CITY OF ALBUQUERQUE

**RE: Westgate Community Center
10001 DeVargas Rd SW
Grading and Drainage Plan
Engineer's Stamp Date: 10/1/19
Hydrology File: M09D030**

Re: Westgate Community Center - Hydrology File: M09D030
COA Hydrology Building Permit Approval Re-Submittal

DRAINAGE MANAGEMENT PLAN

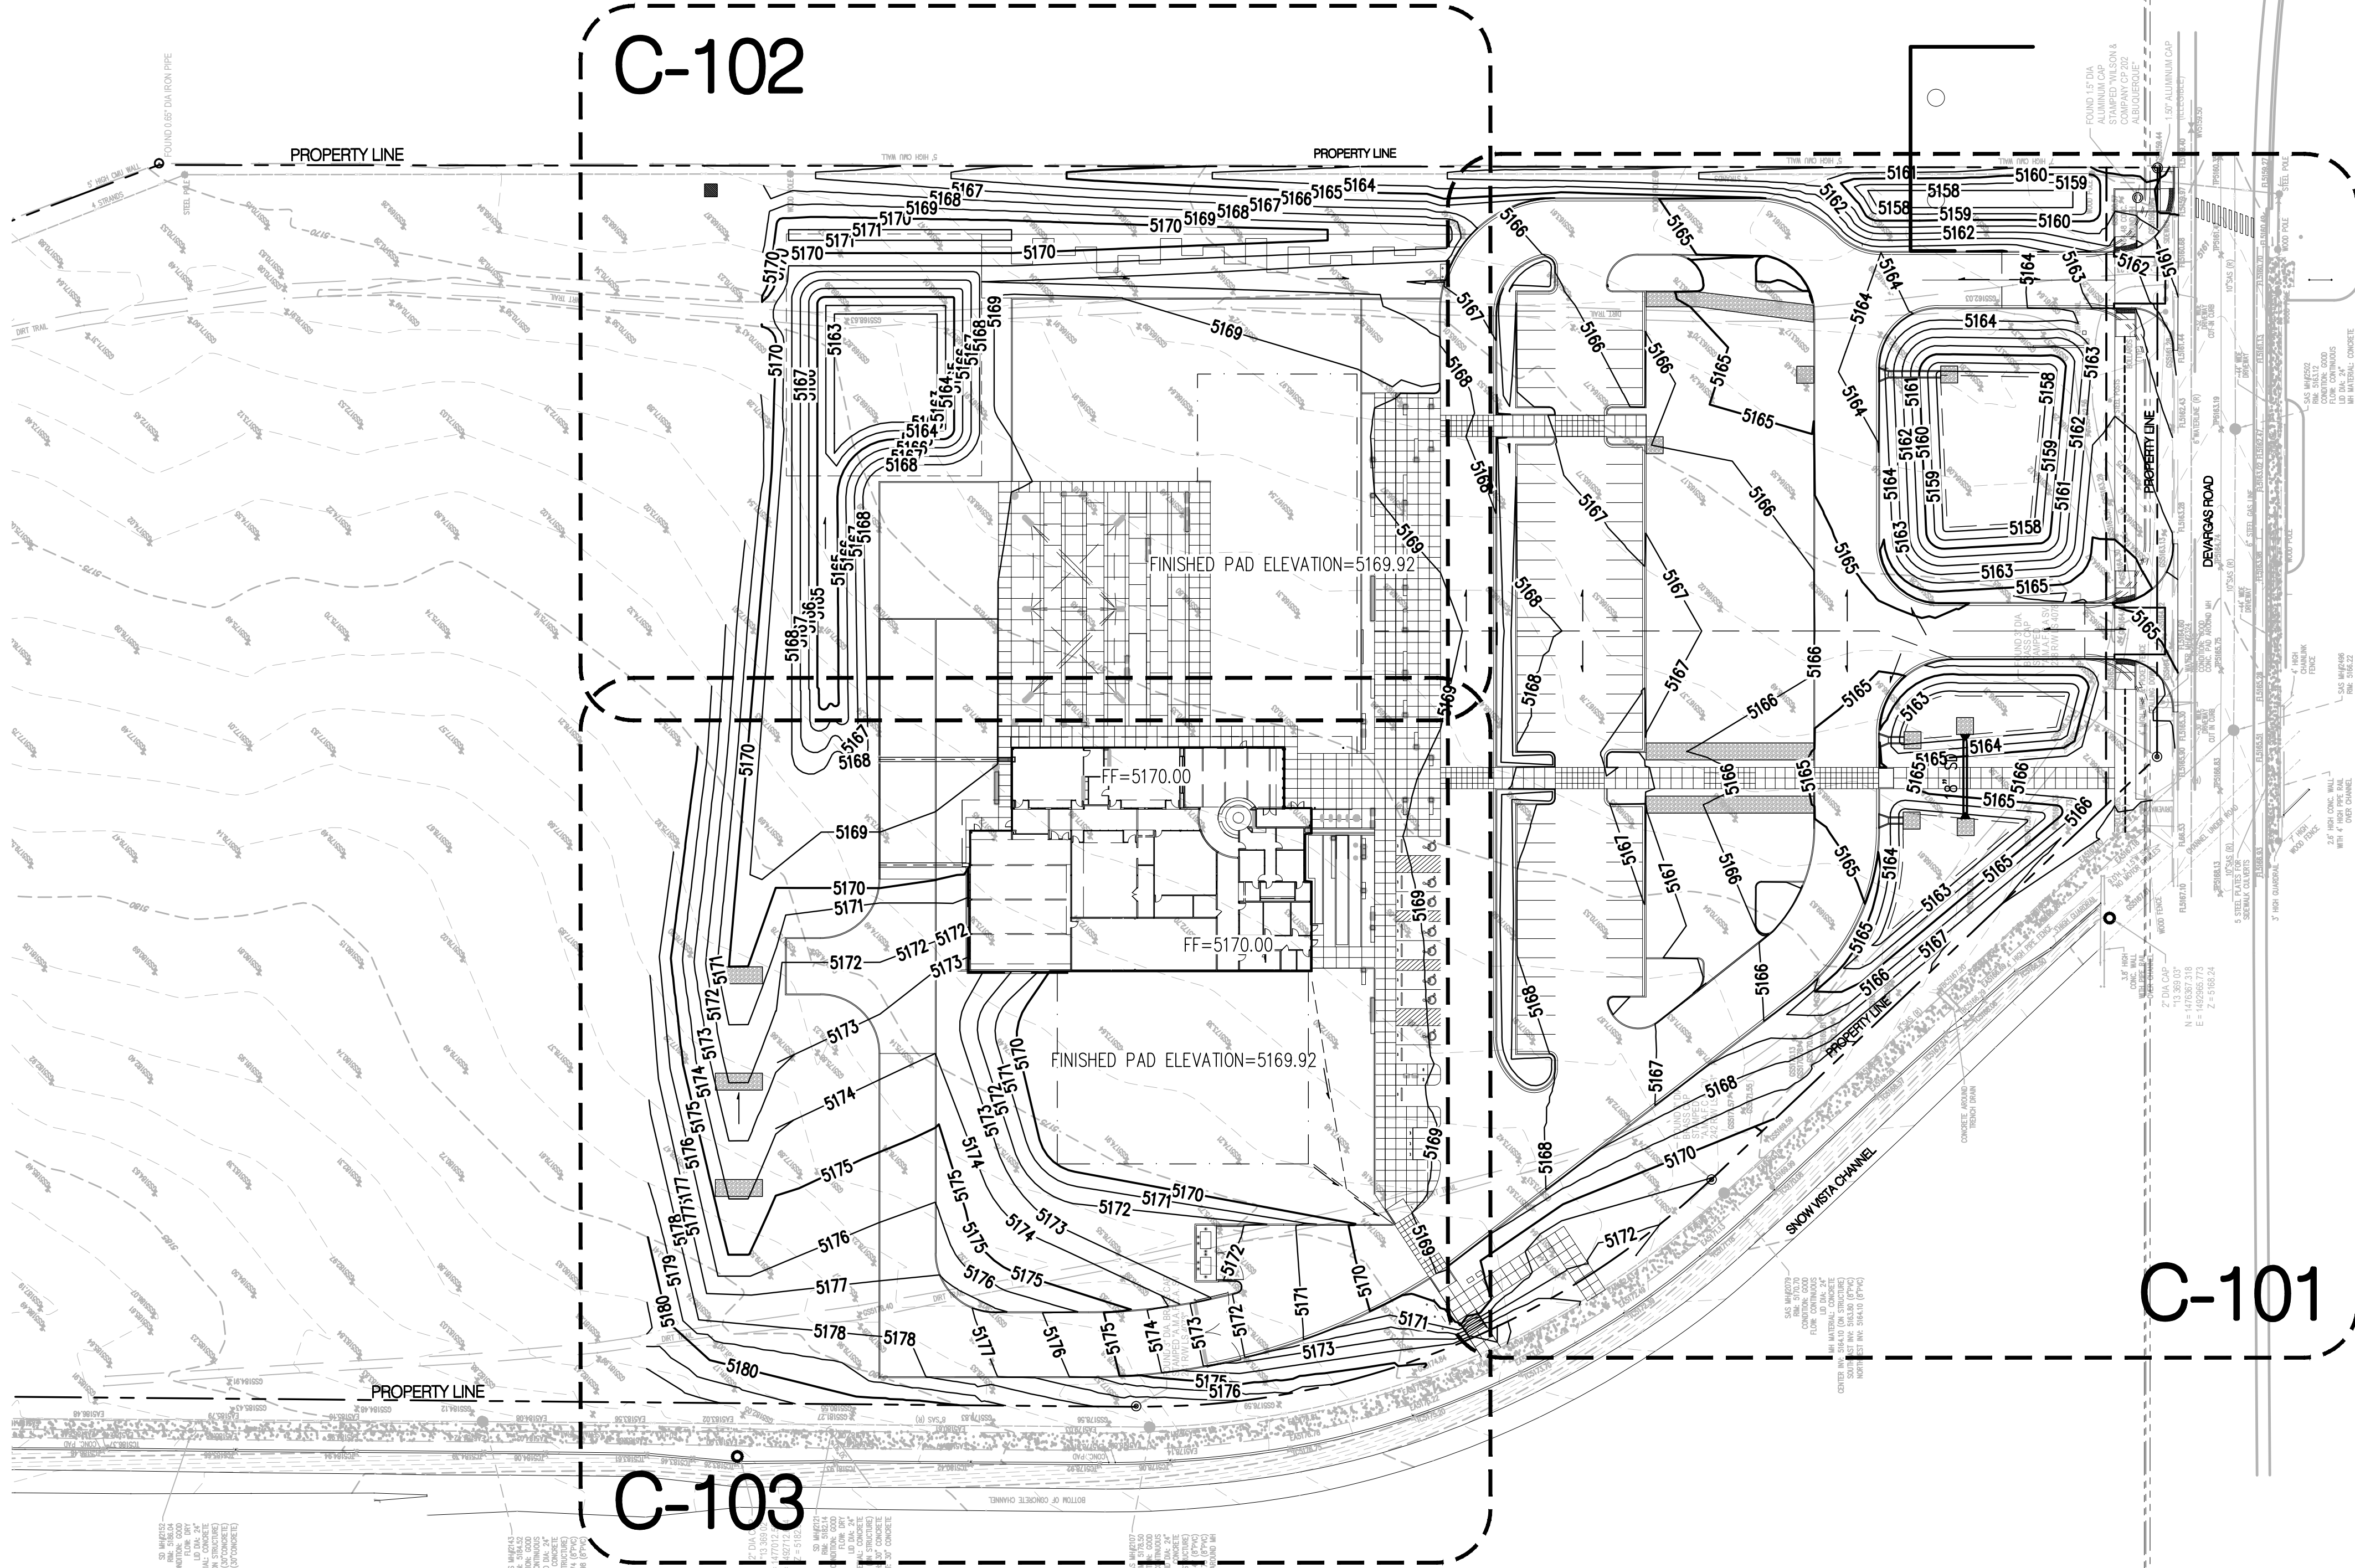
1. Provide an armored emergency overflow from Pond 1; it does not need to be concrete, but it does need to be designed and shown on the stamped grading plan, not the landscaping plan. SW2 is shown in section B-B as a 15' wide swale with unknown depth, but the manning's calculation shows a top width of 45' and a (flow?) depth of 1.63'. The hydraulic calculations must match the section to be constructed. Flow depth needs to be determined in the channel and adequate freeboard provided. Spillway flow depth needs to be determined via the weir equation and adequate freeboard provided along the south and east sides of the pond. Future buildings need to be considered in this design.

Response: Riprap emergency overflow has now been provided. SW2 has been redefined to reflect the appropriate swale cross-section of 15' wide and 1' deep. This spillway is to include 2"-4" rock downstream of the overflow. Weir and Manning's capacities are now provided on the Drainage Management Plan.

OVERALL GRADING AND DRAINAGE PLAN

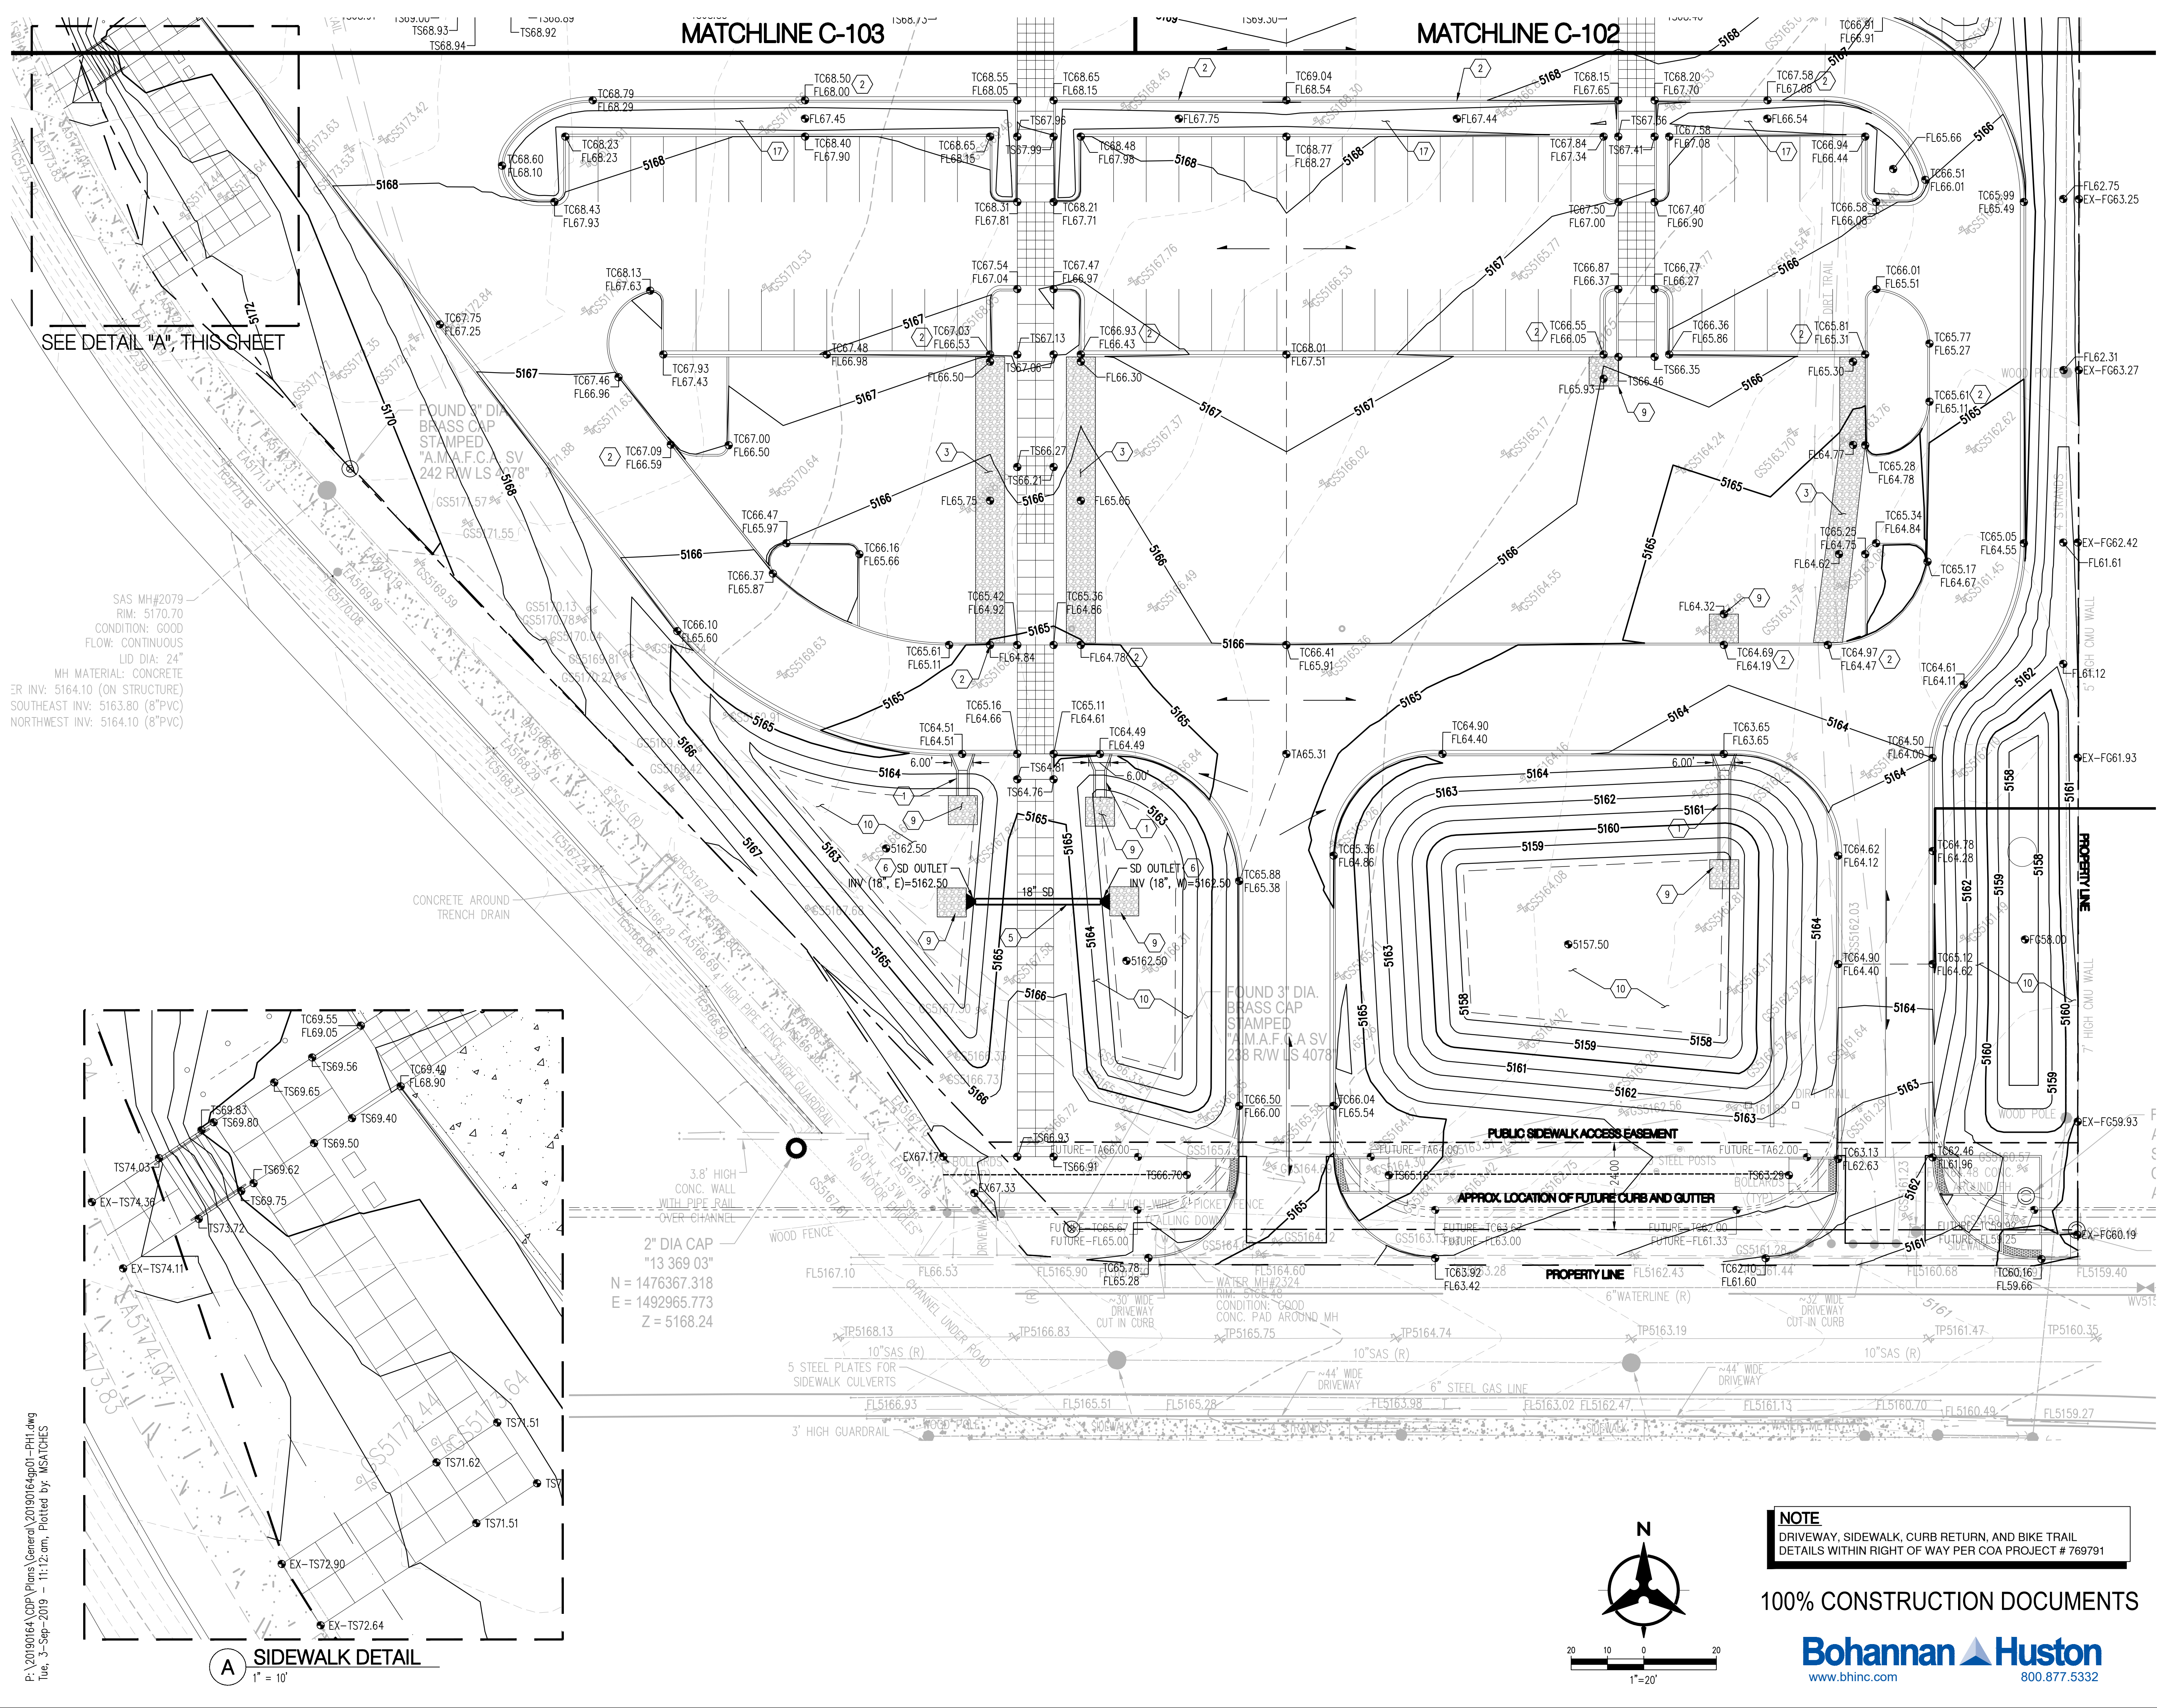
3. Slope stabilization needs to be called out around the western future building pad as well as the berm/swale along the east property line; it may be more reasonable just to reword the general note on C-100 to say "reseed all disturbed areas, including staging areas, per CoA spec section 1012."

Response: General note has been updated to reflect this language.

G CHECK DAM
NOT TO SCALE

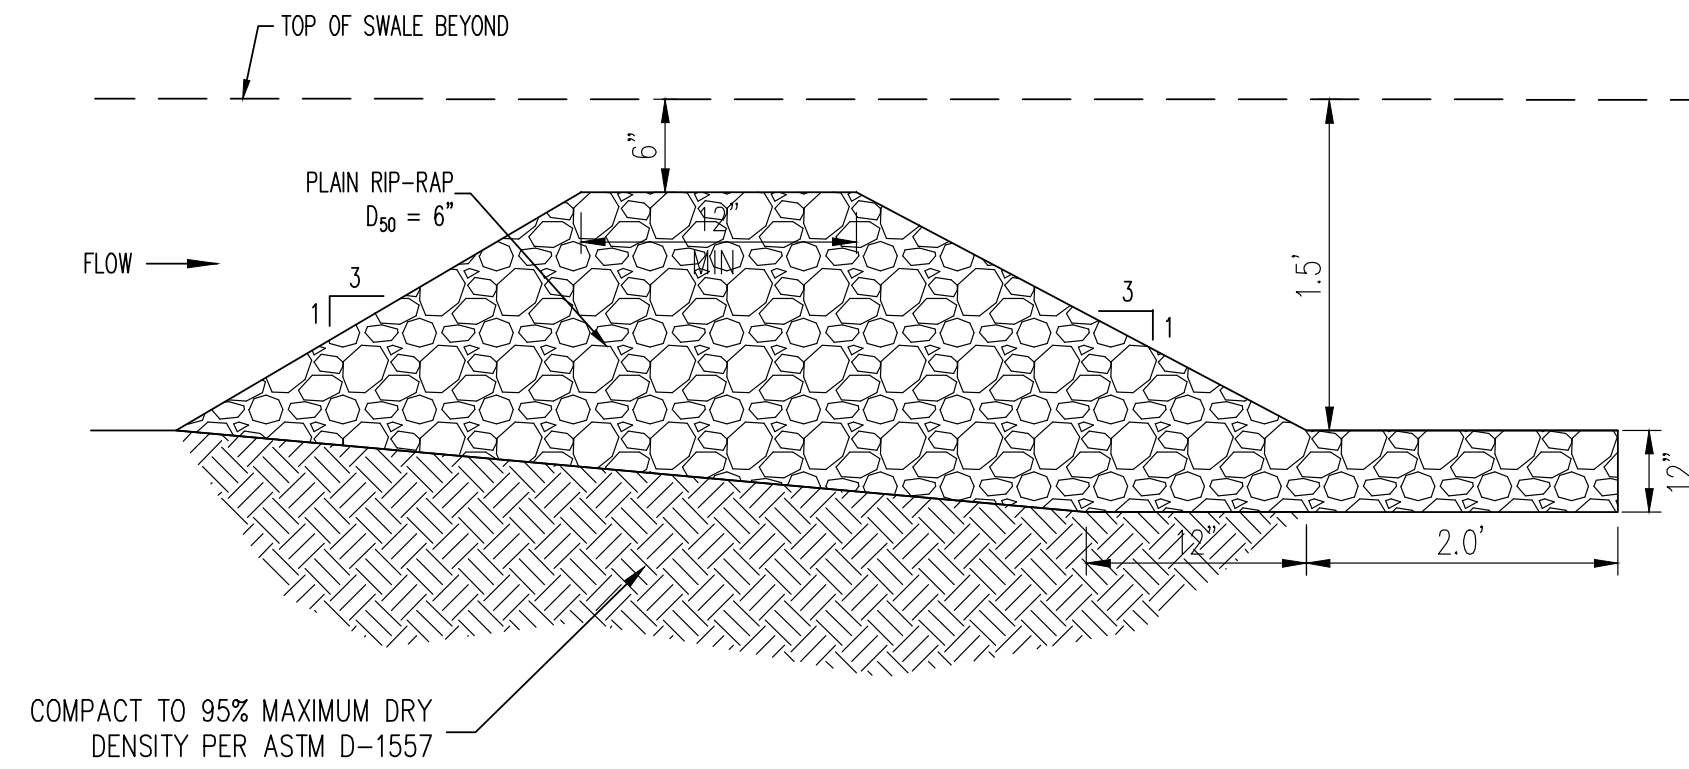
2. Check dams need to be sized and spaced such that the toe of the upstream dam equals the crest of the next downstream dam and provide a sag at midpoint. See NMDOT standards and specifications for temporary erosion and sediment control measures for more details and design standards regarding check dams.

Response: Check dam detail has been updated and placement is based on the crest of the downstream dam and toe of upstream dam per your comment.
